Report of the Coastal West Sussex Panel

Land North of Sefter Road, Pagham

19th July 2021

Reference number	1655/210706
Date	6 th July 2021
Meeting location	Online via Zoom
Panel members attending	Lorraine Farrelly (chair), architecture and urban design Maggie Baddeley, planning and housing Steven Bee, historic environment and urban design John Pegg, landscape architecture and urban design David Prichard, architecture and urban design
Panel manager	Kiki Gkavogianni, Design South East
Presenting team	Ben Baillie, Cooper Baillie Architects Jane Piper, Barton Willmore Greg Collins, CSA Environment Lynn Pack, Taylor Wimpey
Other attendees	Rachael Gardner, Taylor Wimpey Claire Potts, Arun District Council Martyn White, Arun District Council Brenda Louisy-Johnson, Arun District Council (observing)
Site visit	This review was carried out during the Covid-19 outbreak in 2020/21. Independent site study and a digital walk-around (in a similar fashion to that which would have been conducted on-site) was carried out prior to the review.

Pagham North Context Plan

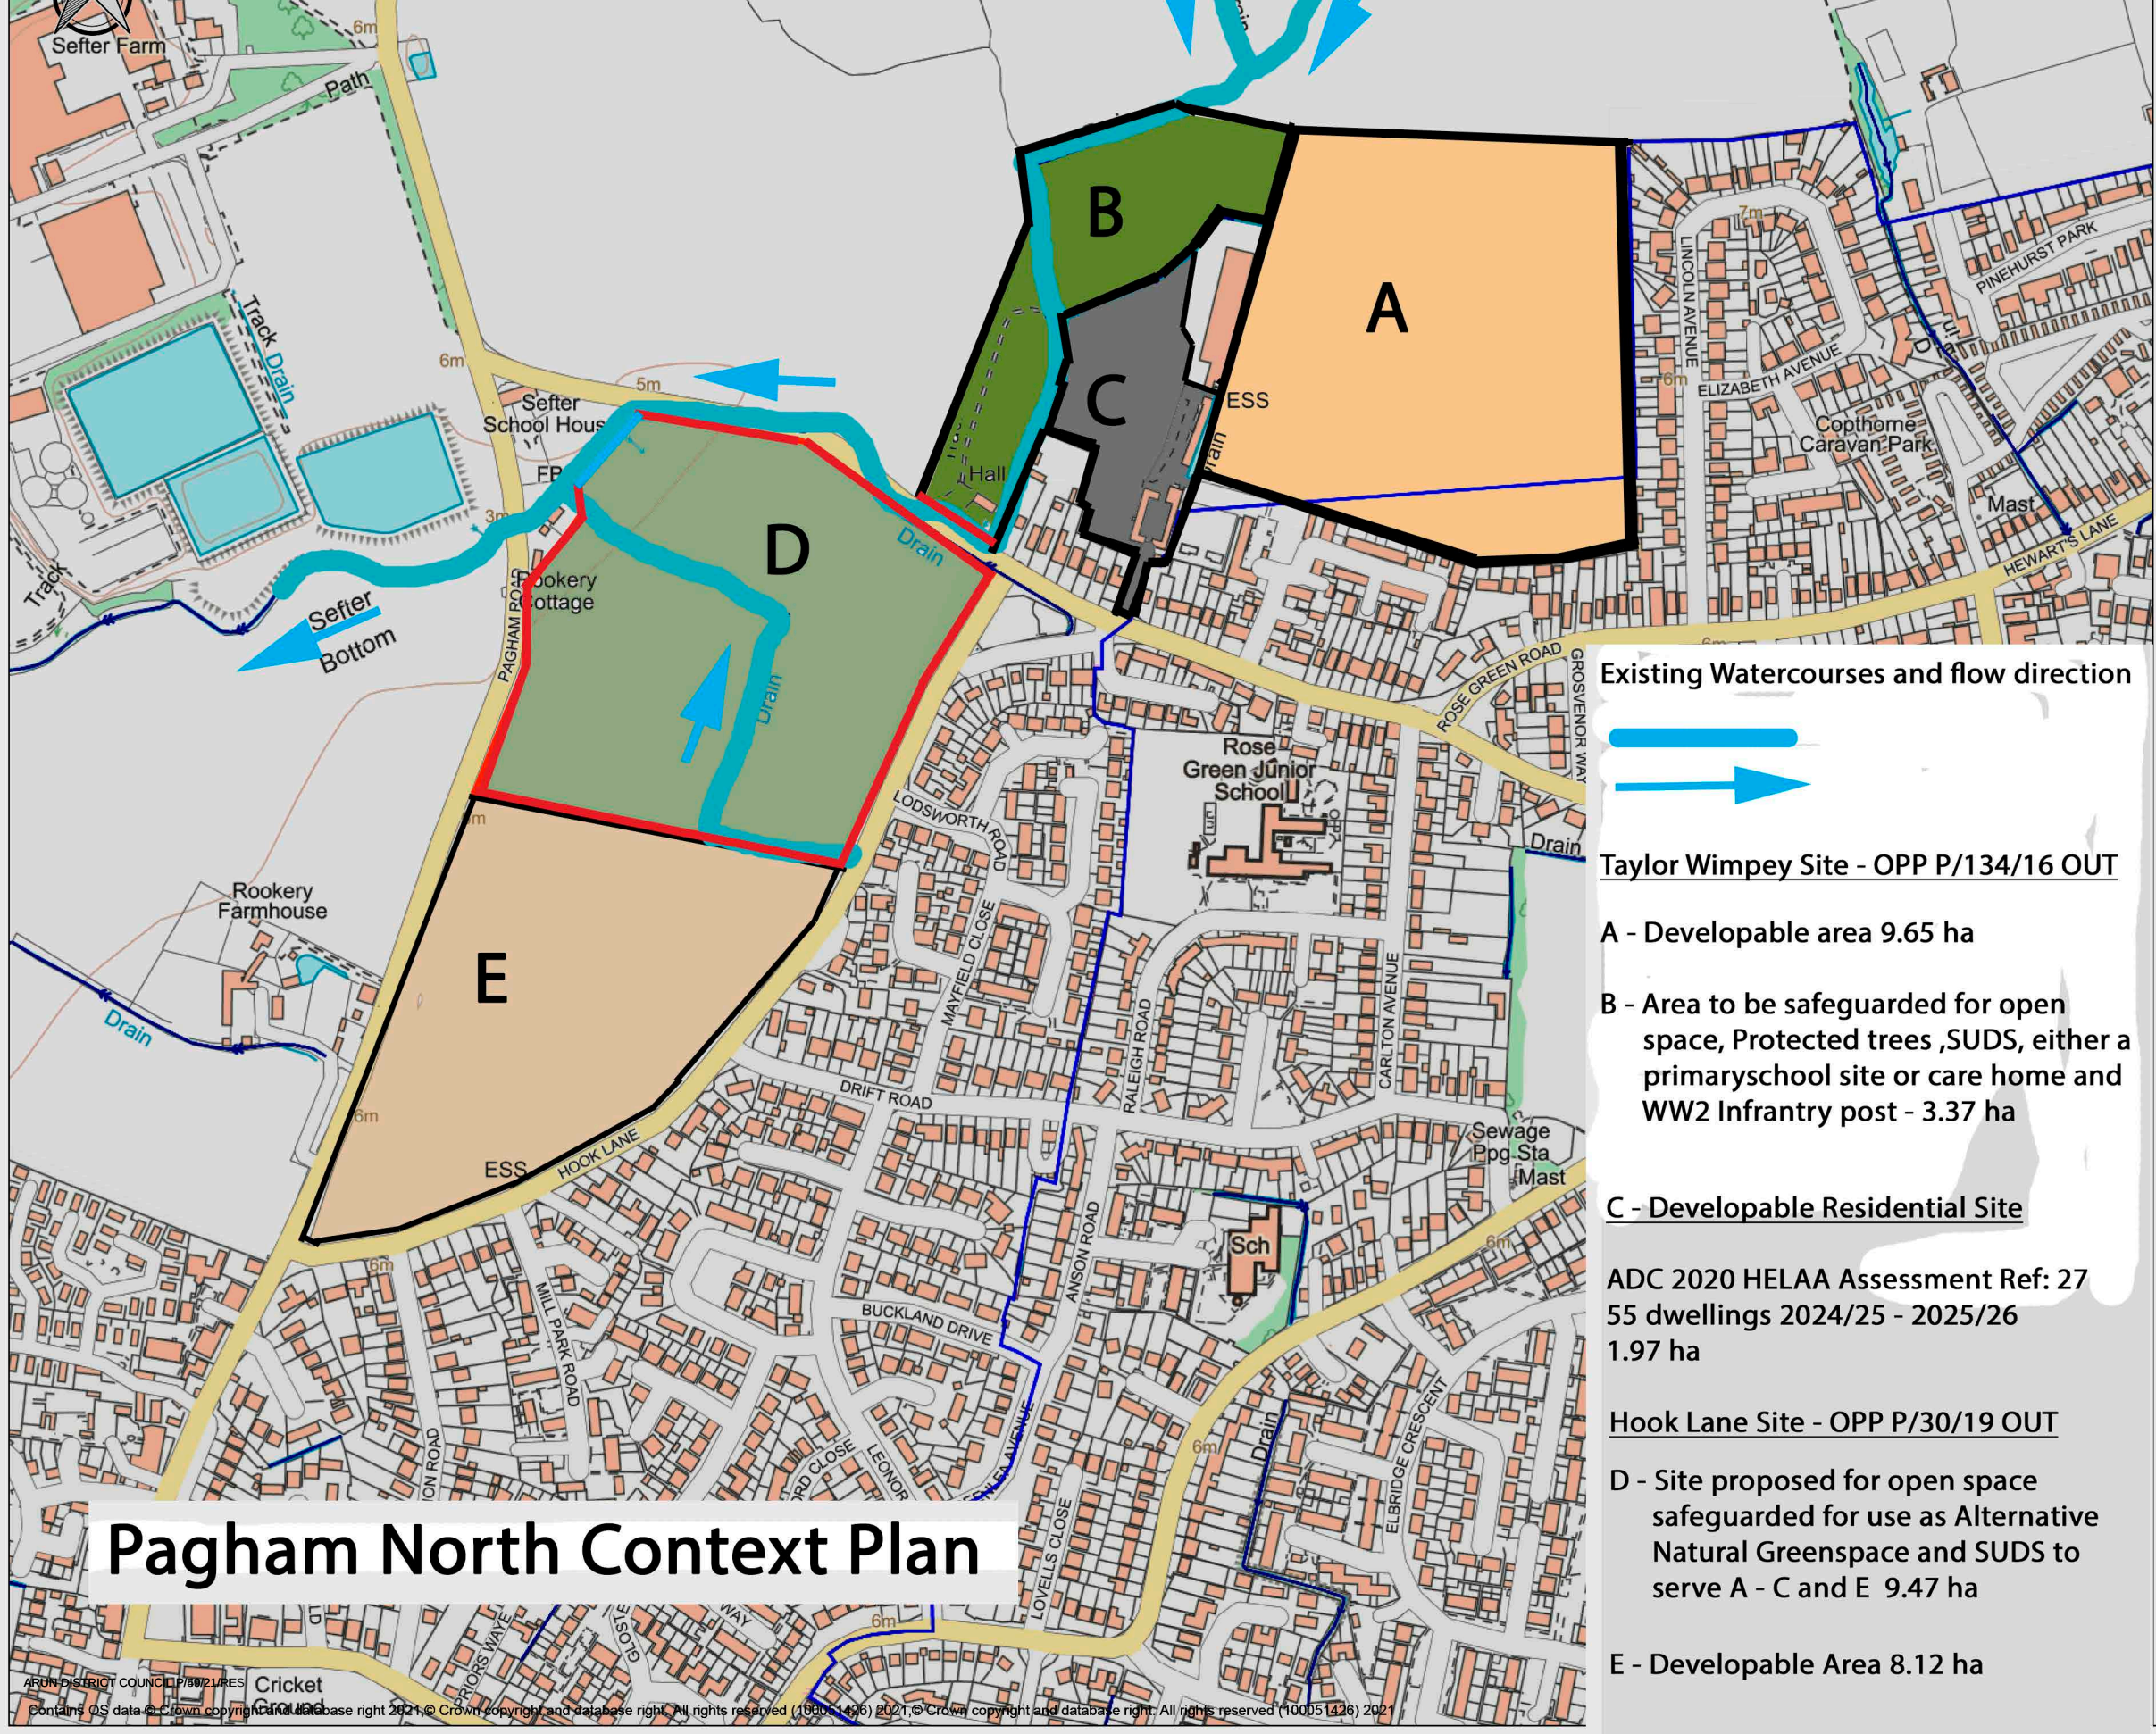
3. Landscape and open spaces
 - 3.1. We applaud the aspiration of a landscape-led masterplan, yet this has failed to materialise in the overall design. The proposal does not integrate with its surroundings, mainly as a result of the landscape-led vision not starting with understanding the context. The missed opportunity of utilising the northern edge and the anti-tank drain is a clear indication of this error.

- 3.4. The existing anti-tank drain and the northern edge can be incorporated into the design of the proposal and contribute positively in three ways: firstly, as part of the sustainable drainage system of the site if surface water is directed towards them; secondly, enhancing the value of the non-designated heritage asset; and thirdly, enhancing the biodiversity of the site. Therefore, we urge the design team to reconsider their approach to drain surface water to the south of the site and then back to the north and to utilise what is already in place to address flood risk.

1. Utilise the anti-tank drain to reinforce the interpretation and ecological value of the heritage asset, add value and improve the sustainable drainage system.
